Contact Julia Puton
Email FRMConsultations@hertfordshire.gov.uk

Date 07 February 2020

RE: 6/2019/1788/COND – Former Shredded Wheat Site, Broadwater Road, Welwyn Garden City, AL8 6UN

TYPICAL ATTENUATION POND DETAIL

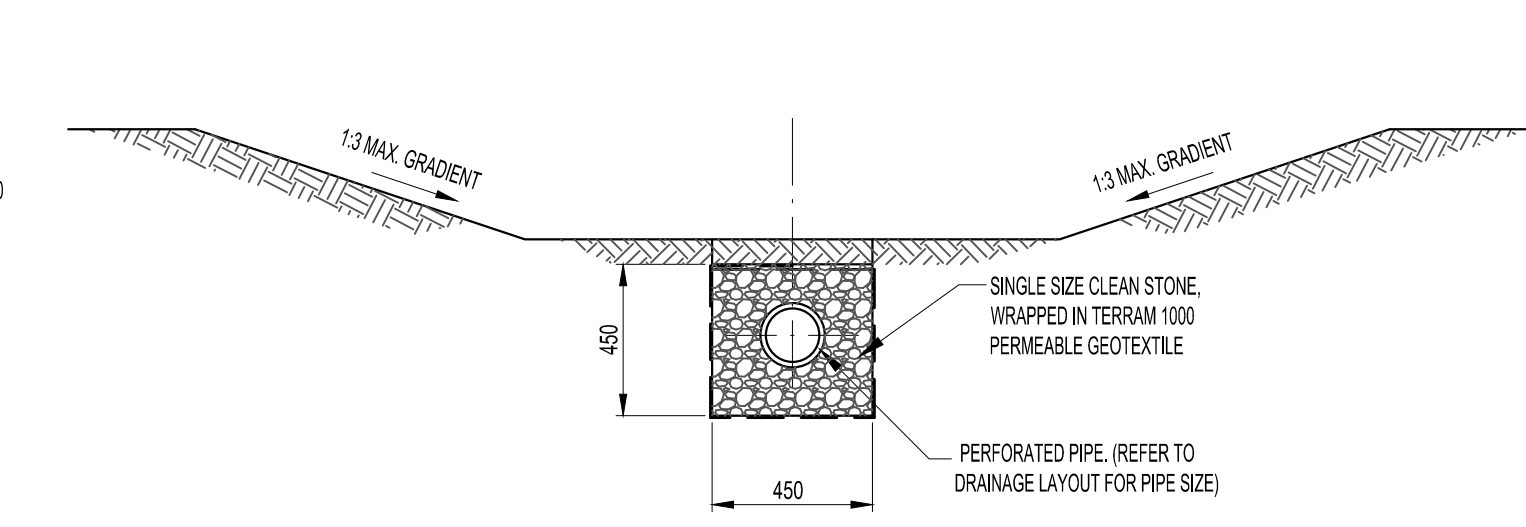
The applicant has submitted multiple drawings of proposed drainage network structures and the proposed SuDS ponds for phase 1. We acknowledge that cross sections have been provided. However, no information on planting and landscaping has been provided. As the proposed features will act as amenity features and should provide multiple biodiversity and sustainability benefits, we believe as this information is crucial on determination if the proposed features are fit for purpose.

PROPOSED DRAINAGE LAYOUT (PHASE 1)

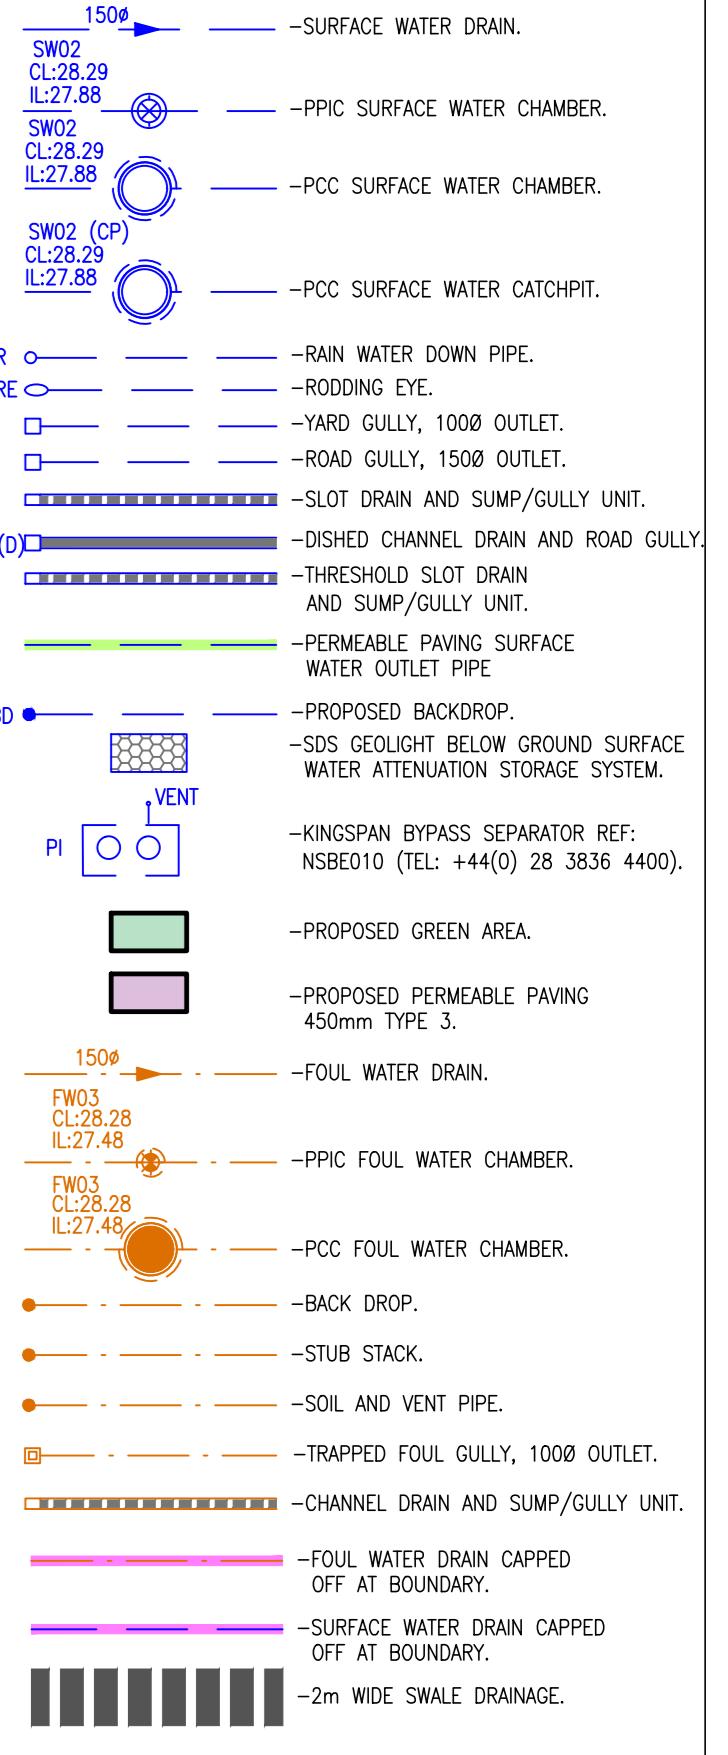
The applicant has submitted the Proposed Drainage Layout drawing, revision P06, dated 10.01.2020. We note that the final discharge rates have been updated and limited to Greenfield runoff rates for the relevant rainfall events. Therefore, a complex flow controls are being proposed for all three proposed outfalls. We are happy to see that the applicant was able to restrict the final discharge from the site to Greenfield runoff rates. From the general notes included on the drainage layout drawing we note that an updated modelling should be provided. However, no such modelling has been submitted to the LPA. Therefore, we would advise the LPA that the applicant should provide an updated modelling in accordance with the latest updates.

We note that an updated catchment layout drawing has been provided. However, as we have stated in our previous letter, having reviewed all details submitted in support of the new, proposed drainage sub-catchments, as the LLFA, we were only able to identify 2 different drainage sub-catchments (sub-catchment 1 and 2). Sub-catchment 2 and 3 are linked together via the proposed dry pond and therefore should be identified as one drainage sub-catchment. Therefore, this should be appropriately modelled as such.

We understand that permeable paving structures have been proposed for surfacing for private terraces, parking spaces and footpaths. Modelling should correspond with the updates. We have noticed that some of these areas have been connected into the wider drainage network on the development site. However, based on the documents provided in support of the 6/2019/1788/COND planning application, the applicant still has not provided any information on the identified contamination areas. Therefore, the proposed drainage strategy including infiltration into the ground from permeable paving areas should not be acceptable.

In relation to point 1, we can confirm that the applicant has submitted an updated drainage layout for the entire South Site (three sub-catchments in total). Drainage details of sub-catchment 1, sub-catchment 2 and sub-catchment 3 have been provided. However, as we have stated before, the submitted modelling and the drainage catchments plan should be updated and should only include two different drainage sub-catchments.

The submitted drainage layout identified three overflow features (dry pond). As we have stated in our previous letter, we would advise that this should be clarified and appropriately modelled. The applicant should clarify at which rainfall event the proposed overflow features will be used and what will be the maximum water level in each feature.

In relation to point 4 of condition 6, detailed drainage layout has been submitted. However, a catchment map will need to be updated.

In relation to points 5 and 6 of condition 6, as we have stated before, we are satisfied with the information provided. However, we would like to remind that the submitted drainage layout drawing should be updated in line with the above comments.
